Appeal Decision

Appeal Ref: APP/A2525/W/17/3175611

1 Woolram Wygate, Spalding PE11 1NX

- The appeal is made under section 78 of the Town and Country Planning Act 1990 against a refusal to grant planning permission.
 - The appeal is made by Mr S Cole, Glen Holland Ltd Pension Plan against the decision of South Holland District Council.
 - The application Ref H16-0110-17, dated 3 February 2017, was refused by notice dated 26 April 2017.
 - The development proposed is change of use – office accommodation to house of multiple occupation.
-

FLOOR PLAN - PROPOSED
LOCATION PLAN

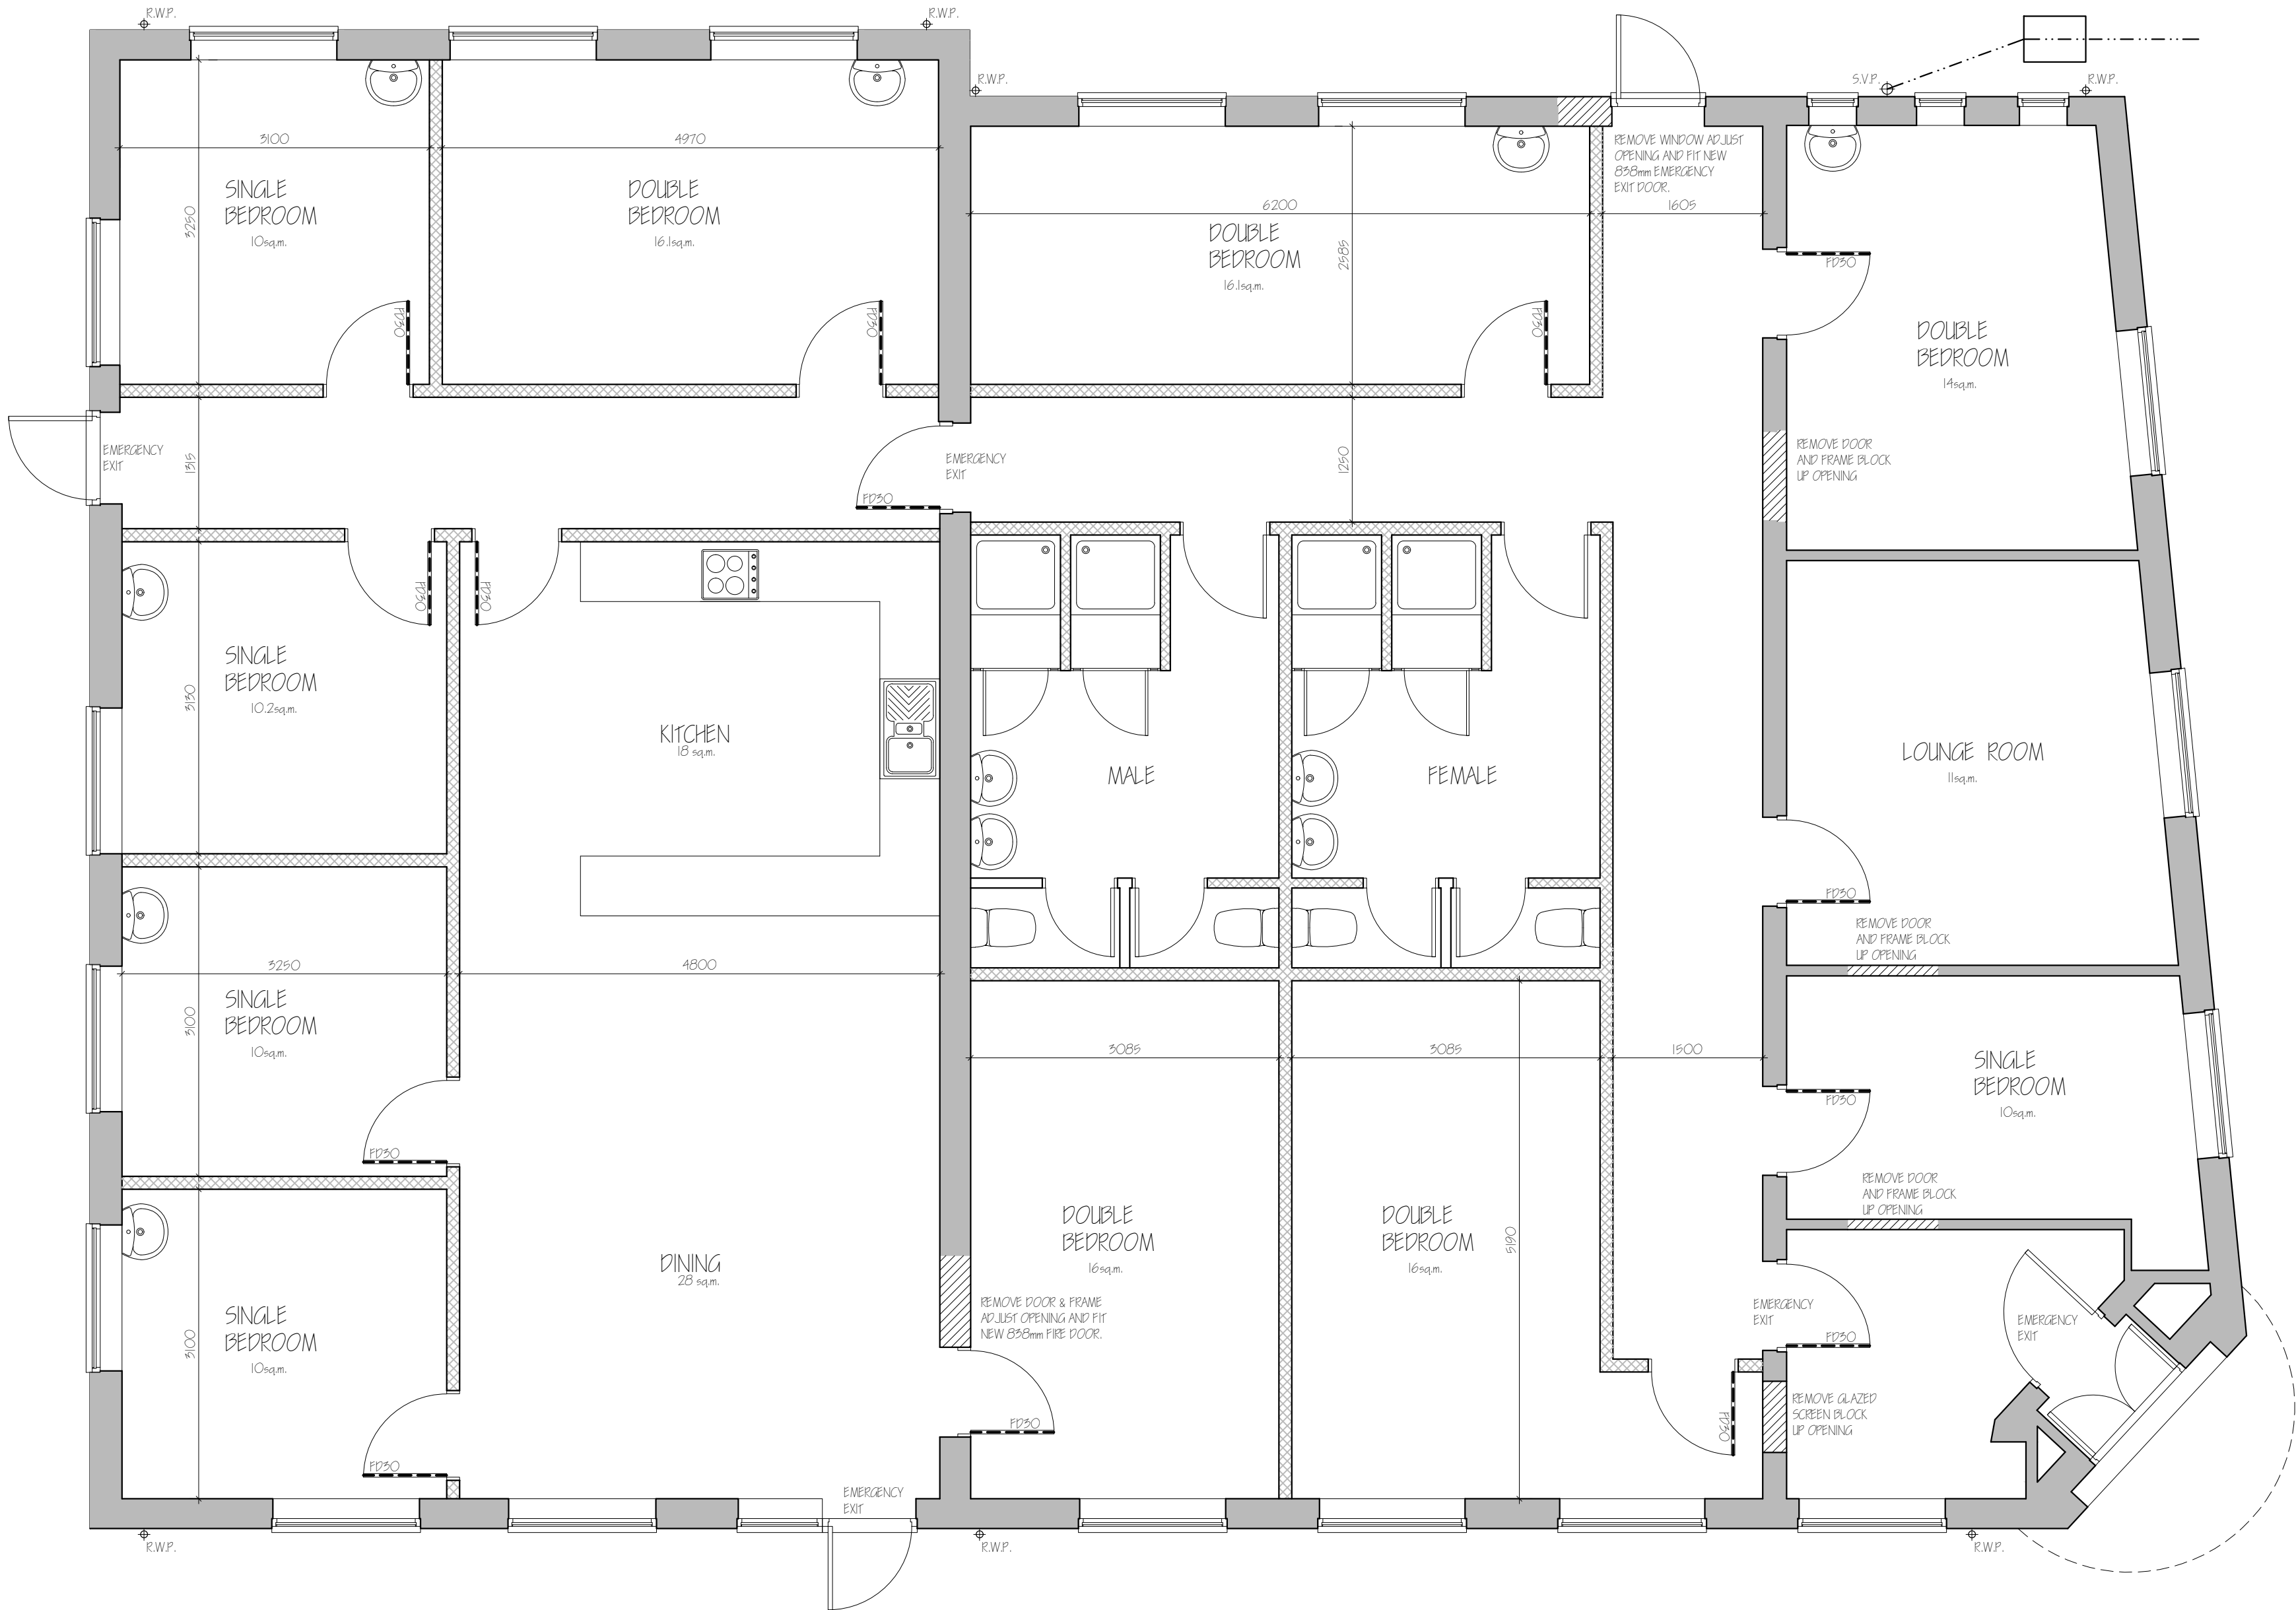
5. The Revised Floor Plan Ref 1663-02 Rev A shows five single and five double rooms with potential for 15 occupants. There would be two shared bathrooms each containing two showers and two toilets identified as separate male and

- female facilities. The plan shows a lounge room, and a kitchen/dining area with two cookers with four rings, one microwave oven and two kitchen sinks.

7. A copy of the Guide has not been provided and therefore I cannot confirm whether the proposed layout, including room sizes, conforms to it. In any event it seems to me that, as shown on the plan, there would be a rather sparse amount of kitchen facilities if future occupants lived separately, and I have no evidence before me to indicate they would live as a cohesive group. Similarly the extent and arrangement of the proposed shower/toilet facilities seems low for fifteen occupants particularly as there is no certainty regarding how many male or female occupants there might be. Four of the proposed bedrooms would only be accessible through the shared dining/kitchen room which is unsatisfactory in terms of privacy. I remain of this view whether or not Private Sector Housing raised objections or whether HMOs elsewhere are of a lesser standard.

8. Use as a HMO is a residential use and, in principle, there would be no objection to a residential use in a residential area. The LP recognises that HMOs are an intensive use. No private external amenity space is proposed on the plans and no provision for storage and disposal of waste has been indicated. Whilst facilities for the storage and disposal of refuse could be secured by planning condition this would be likely to be at the expense of parking.
